**CITY OF PORTLAND, MAINE
DEVELOPMENT REVIEW APPLICATION
PLANNING DEPARTMENT PROCESSING FORM**

Kansas Ave. Lot# 23

BUILDING PERMIT REPORT

DATE: July 2001 ADDRESS: 82 Kansas Ave. (G#2) CBL: 399-D-008

CONCEPTUAL GRADING PLAN; SCALE 1"=30'
 LOT 23 PINES (82 KANSAS AVE.)
 PLOT PLAN Prepared By Greg McCormack
 Based on Grading Plan Prepared
 by PINKHAM + Greer ENGINEERS
 Dated 9/10/99

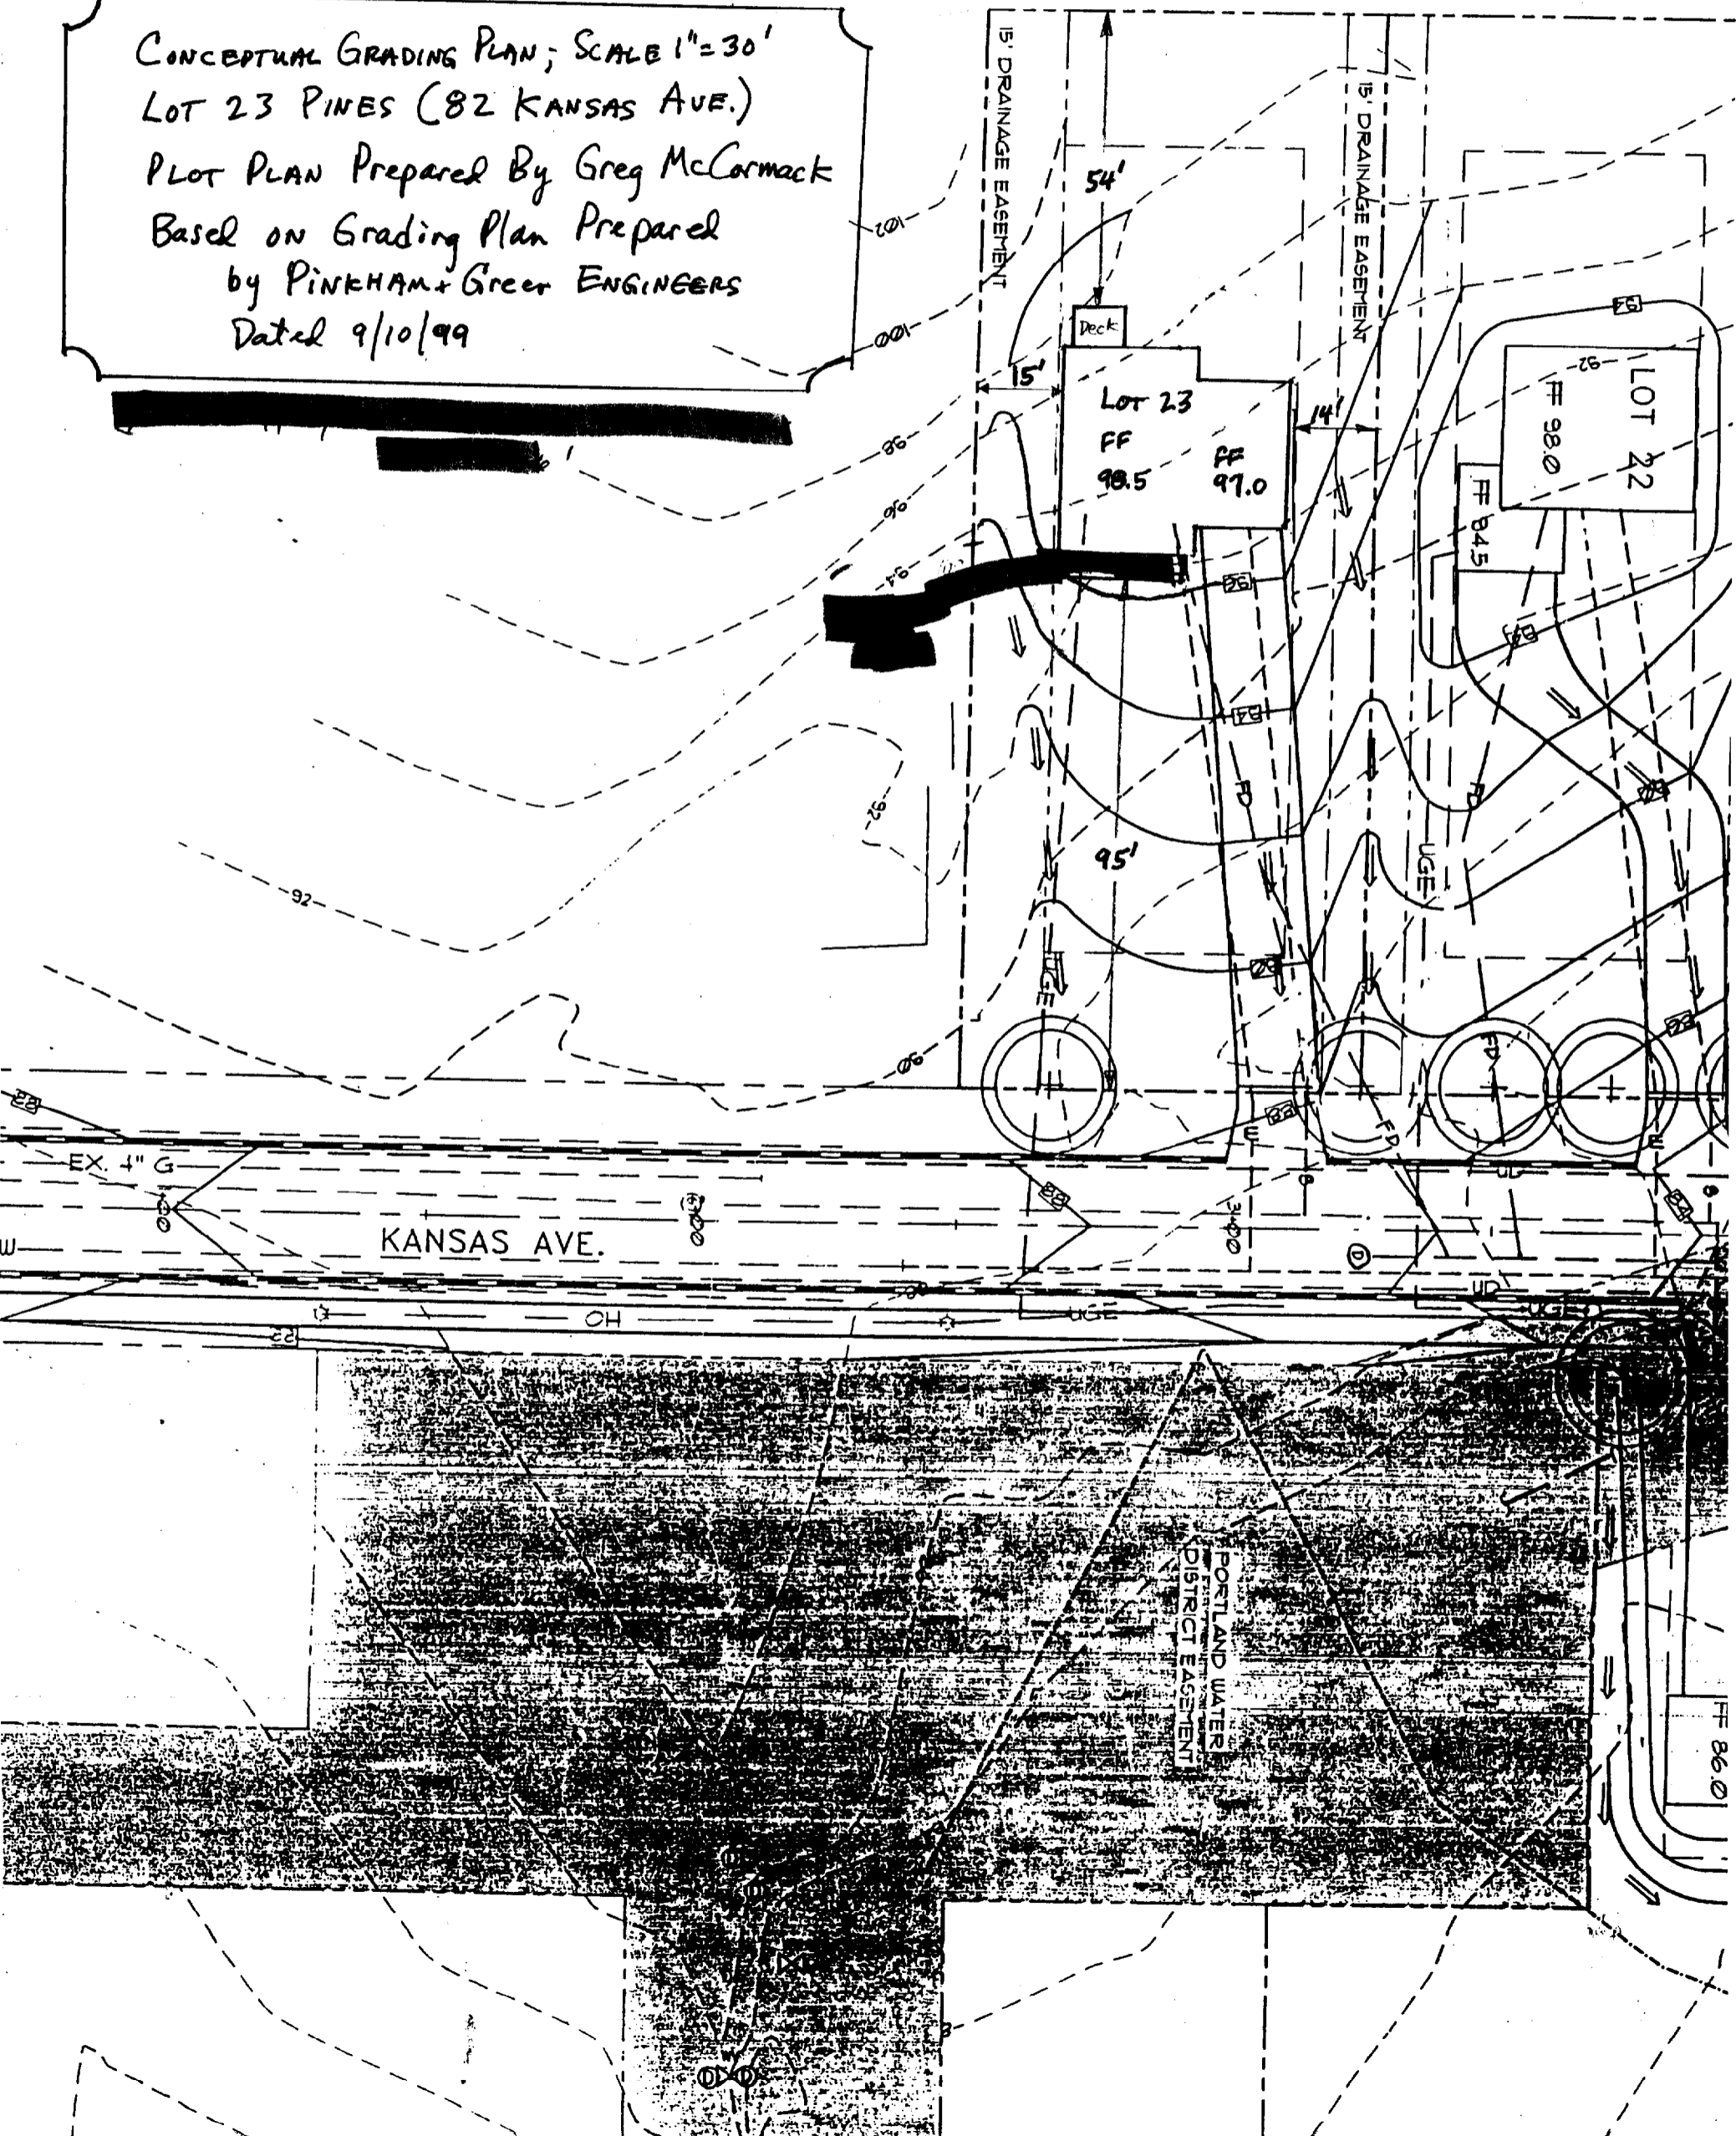
- 11 The building contractor shall check the subdivision recording plat for pre-determined first floor elevation and establish the first floor elevation (FFE) and sill elevation (SE) to be set above the finish street/curb elevation to allow for positive drainage away from entire footprint of building.

- 12 The site contractor shall establish finish grades at the foundation, bulkhead and basement windows to be in conformance with the first floor elevation (FFE) and sill elevation (SE) set by the building contractor to provide for positive drainage away from entire footprint of building.

- 13 A drainage plan shall be submitted to and approved by Development Review Coordinator showing first floor elevation (FFE), sill elevation (SE), finish street/curb elevation, lot grading, existing and proposed contours, drainage patterns and paths, drainage swales, grades at or near abutting property lines, erosion control devices and locations and outlets for drainage from the property.
